WEST SUSSEX COUNTY COUNCIL CONSULTATION

TO:	Arun District Council FAO: Amber Willard
FROM:	WSCC - Highways Authority
DATE:	25 February 2020
LOCATION:	Land adjacent to 49 Warren Way, Barnham, PO22 0JX
SUBJECT:	BN/15/20/PL Erection of 1 No.end of terrace two storey 2-bedroom dwelling.
DATE OF SITE VISIT:	N/A
RECOMMENDATION:	Advice
S106 CONTRIBUTION TOTAL:	N/A

Title
SITE & BLOCK PLANS

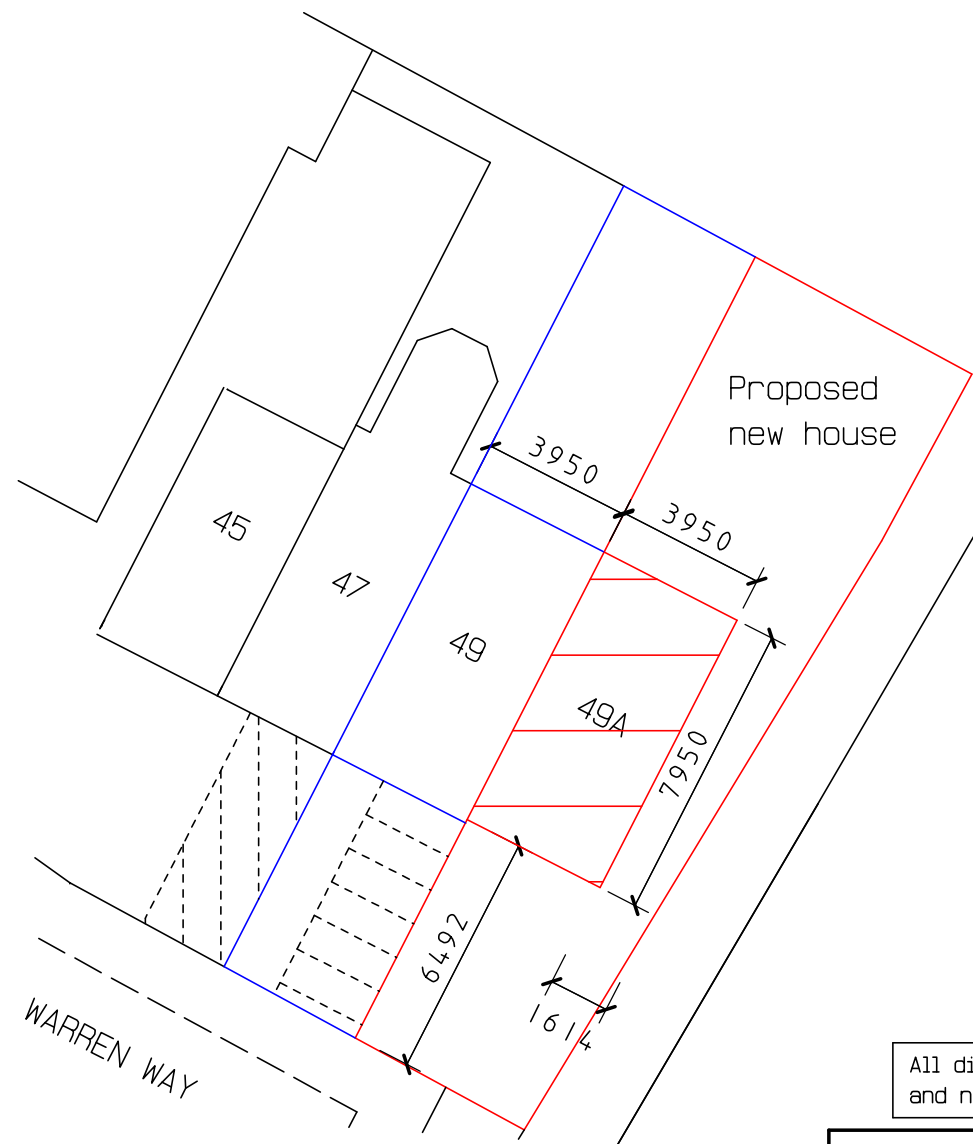
The applicant proposes to widen the existing dropped kerb to allow for a new off-street parking space for the proposed dwelling. The widening of the vehicle crossover (VCO) will be subject to a licence obtained through the local area office. The VCO would be constructed to a specification agreed with the local area engineer.

The applicant proposes one car parking space for the proposed dwelling. The parking area is of sufficient size for one parking space that meets the minimum specifications for single car bays of 2.4m x 4.8m as set out in Manual for Streets (MfS). Under Arun Parking Standards (Adopted January 2020), the LHA would anticipate that two car parking spaces would be sufficient for a dwelling of this size in this location.

Any overspill parking would have to be accommodated on street. Additionally, the proposed access works may result in the loss of one or two existing on-street parking spaces. Whilst the LHA does not anticipate that highway safety would be detrimentally through this proposal, the planning authority may wish to consider the potential amenity impacts that may arise from the loss of one or two on-street parking spaces and a small increase in on-street parking demand.

request that developers provide all new homes with electric vehicle (EV) charging points. Based upon current EV sales rates within West Sussex, the applicant should provide a minimum of 20 % of all proposed parking spaces with active charging points, with ducting in place for the remaining 80% to provide 'passive' provision for future upgrades. Due to the small-scale nature of this proposal, the anticipated provision of active EV spaces for this development would be one space, in accordance with both Arun Parking Standards and WSCC guidance.

The applicant has not demonstrated cycle parking provision. Under Arun Parking Standards, a dwelling of this size should provide secure and covered cycle parking for at least one cycle. The inclusion of cycle parking helps promote the use of sustainable alternative modes of transport to the private car.

No part of the development shall be first occupied until the car parking has been constructed in accordance with the approved site plan. These spaces shall thereafter be retained at all times for their designated purpose.

No part of the development shall be first occupied until covered and secure cycle parking spaces have been provided in accordance with plans and details submitted to and approved by the Local Planning Authority.
